Appeal NO: ABP 321466

Subject: Responses re. St Margaret's Waste Recycling -Substitute Consent Application

Your Reference ABP-321466-24

TITLE
PROPOSED SITE PLAN

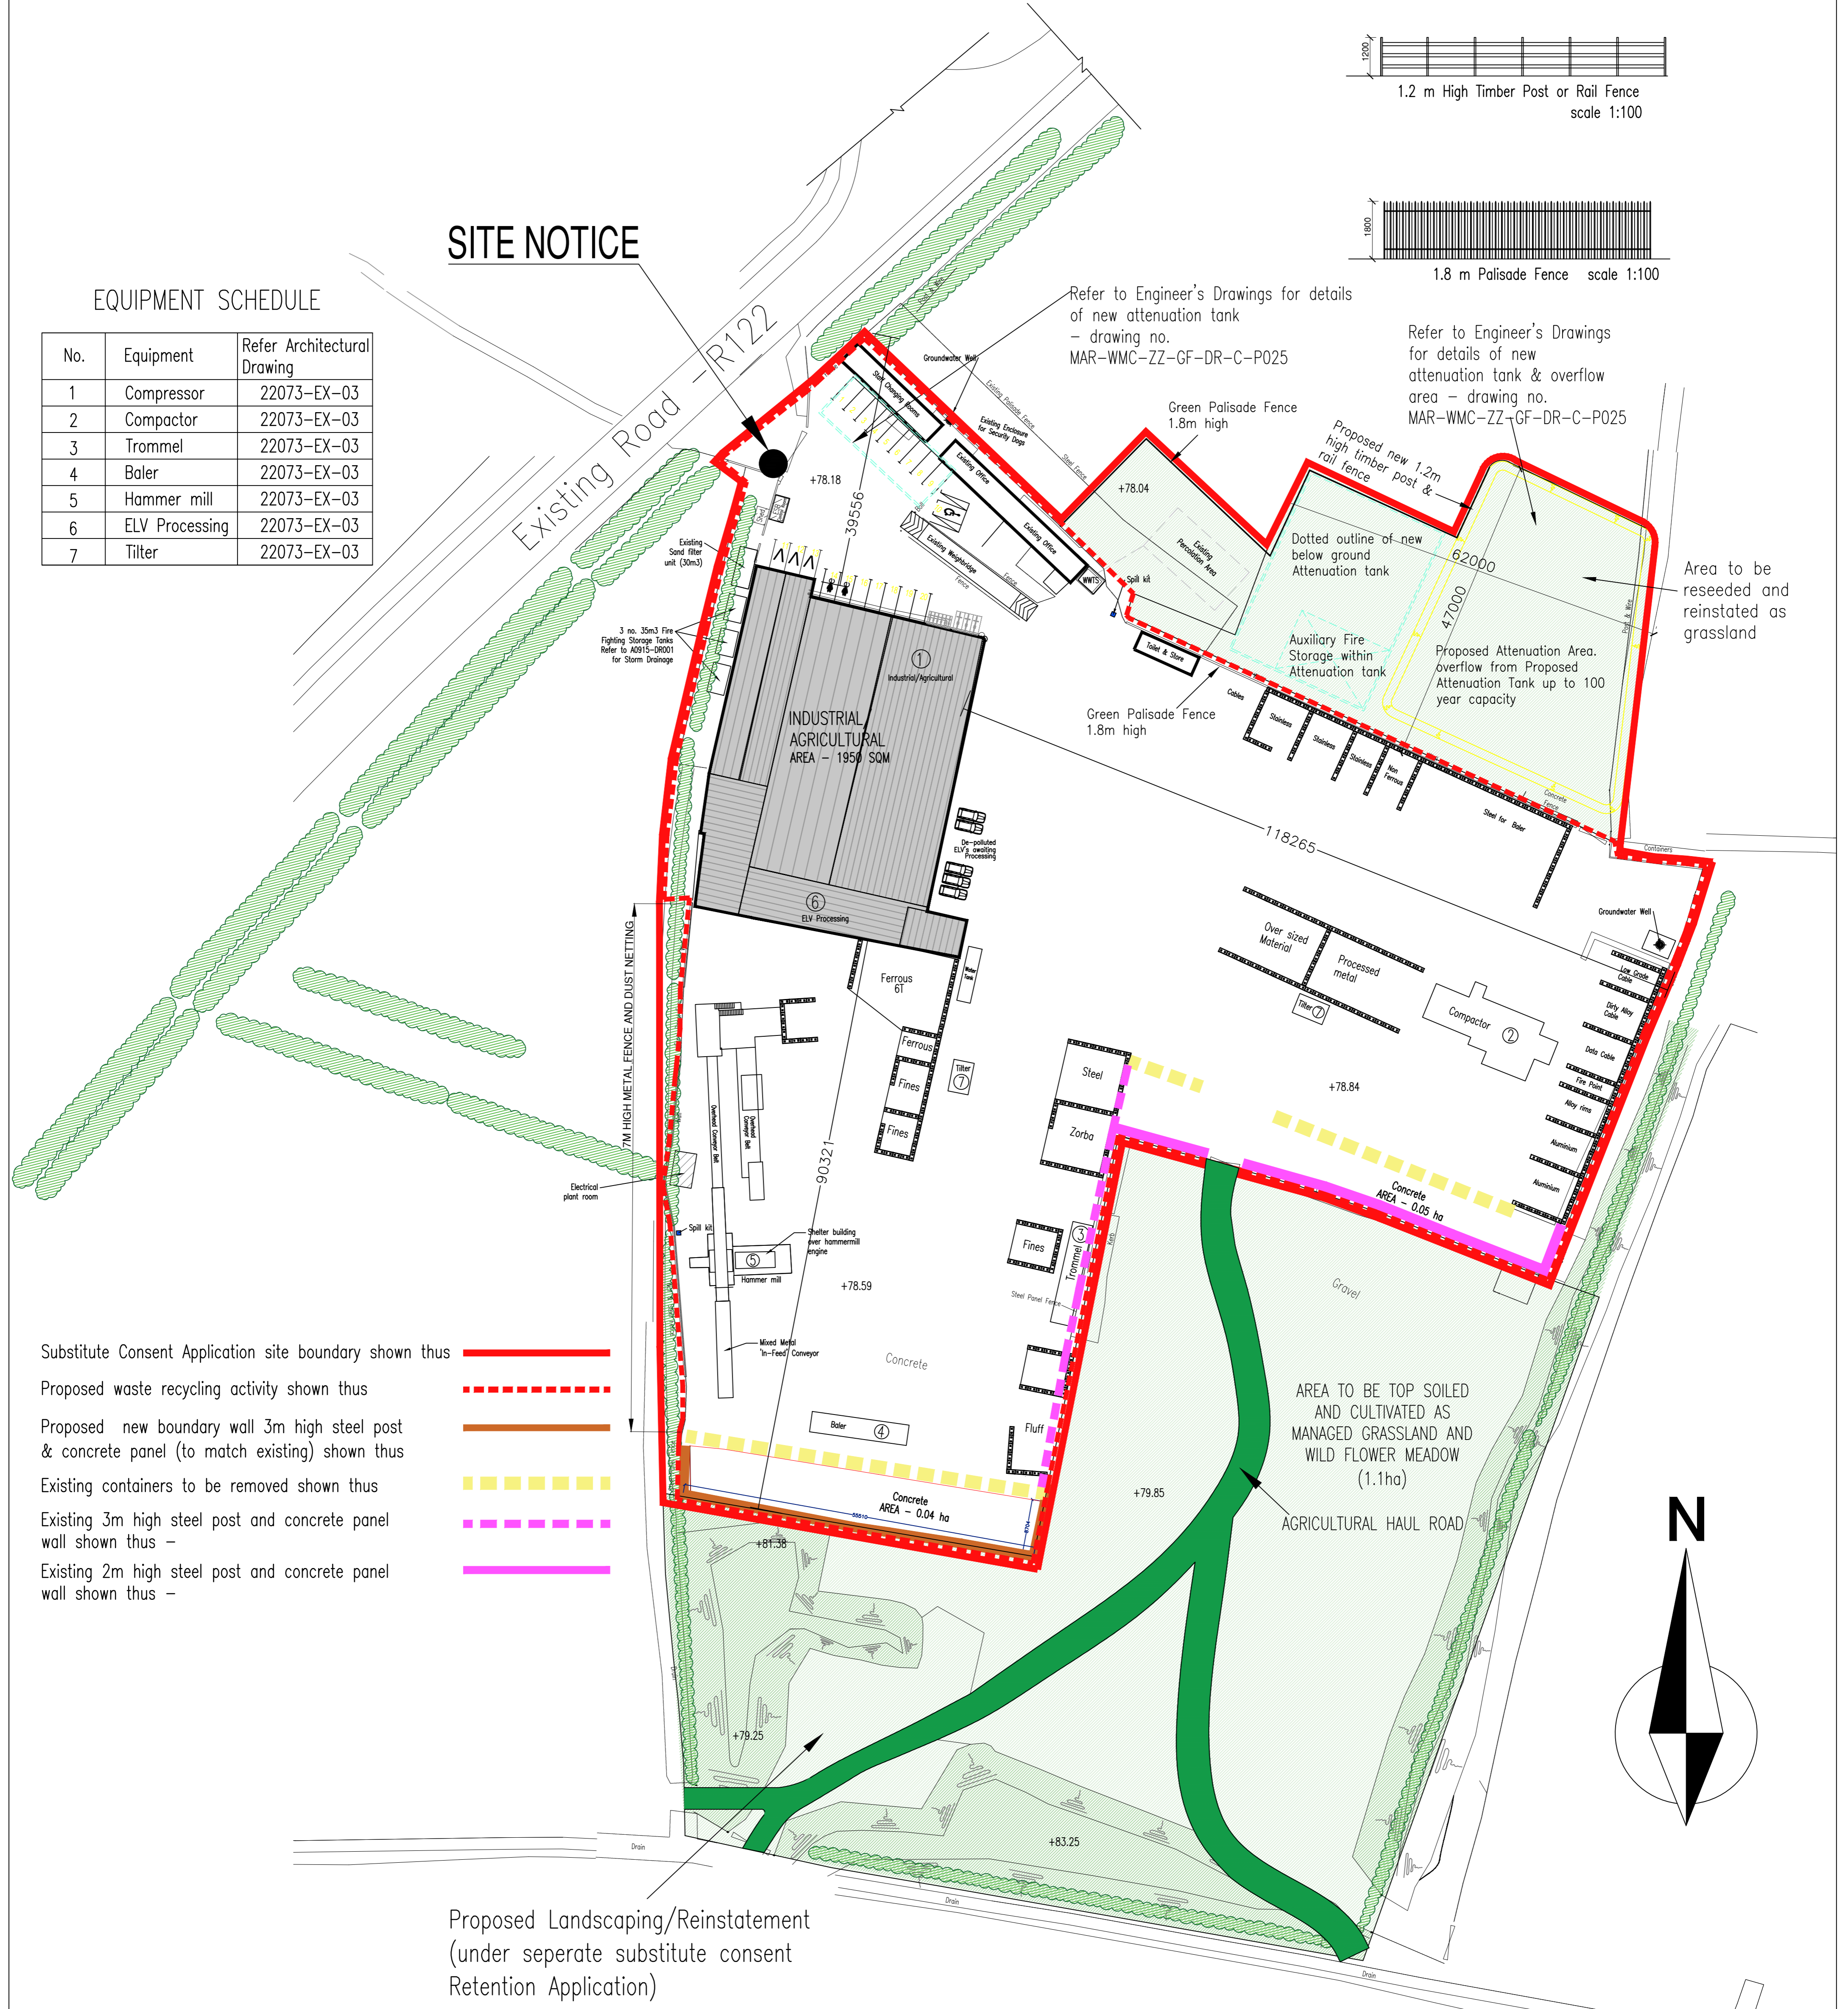
The DAA have made a submission which reflects their concerns regarding 'Wildlife Hazard and Aviation Safety Concerns'.

The proposal to convert the currently hard cored area to a combination of managed grassland and wildflower meadow can be amended to have 'long grass' only, and the applicant can plant tall fescue and Italian ryegrass.

2. **Open Water Attenuation** also appears to be an issue for the DAA, although we note that there are numerous open water sources in this area, and again they have not caused any issue regarding aircraft safety. That said, we have reviewed our proposals and have addressed the concerns here under-

- "the basin's flat profile may result in prolonged water retention" –
In this regard the profile of the basin can be altered to ensure that a minimum of 1/40 falls towards the open grated manholes in the base are achieved. We would also note that proposed basin is located in an existing greenfield area, and therefore no change is proposed in this regard. This 1 in 40 gradient is in excess of the current ground profile and is supplemented by the provision of new land drainage with free draining gravel

In terms of attenuation, the 1 in 30-year attenuation volume is wholly retained below ground, with an above ground dry detention basin only functioning in storms in excess of this return period. There is no open water proposed as part of the proposed development, but rather the basin stores water for short periods in extreme rainfall events (exceeding 1 in 30-year event).

surround in the basin area to prevent water retention in normal conditions. The above would align with the DAA recommendation for "rapid infiltration systems" in the basin area.

- The frequency at which this basin fills
This could also be reduced through the increase in the below ground storage volume if required. This has also been proposed by the DAA as suitable mitigation.
- Netting could also be provided if considered necessary, but the frequency of use of the dry detention basin would not suggest it would be necessary.
- It is proposed that the basin is constructed with a maintained grass base that would restrict any nesting opportunities with the dry basin when compared to the current agricultural use.
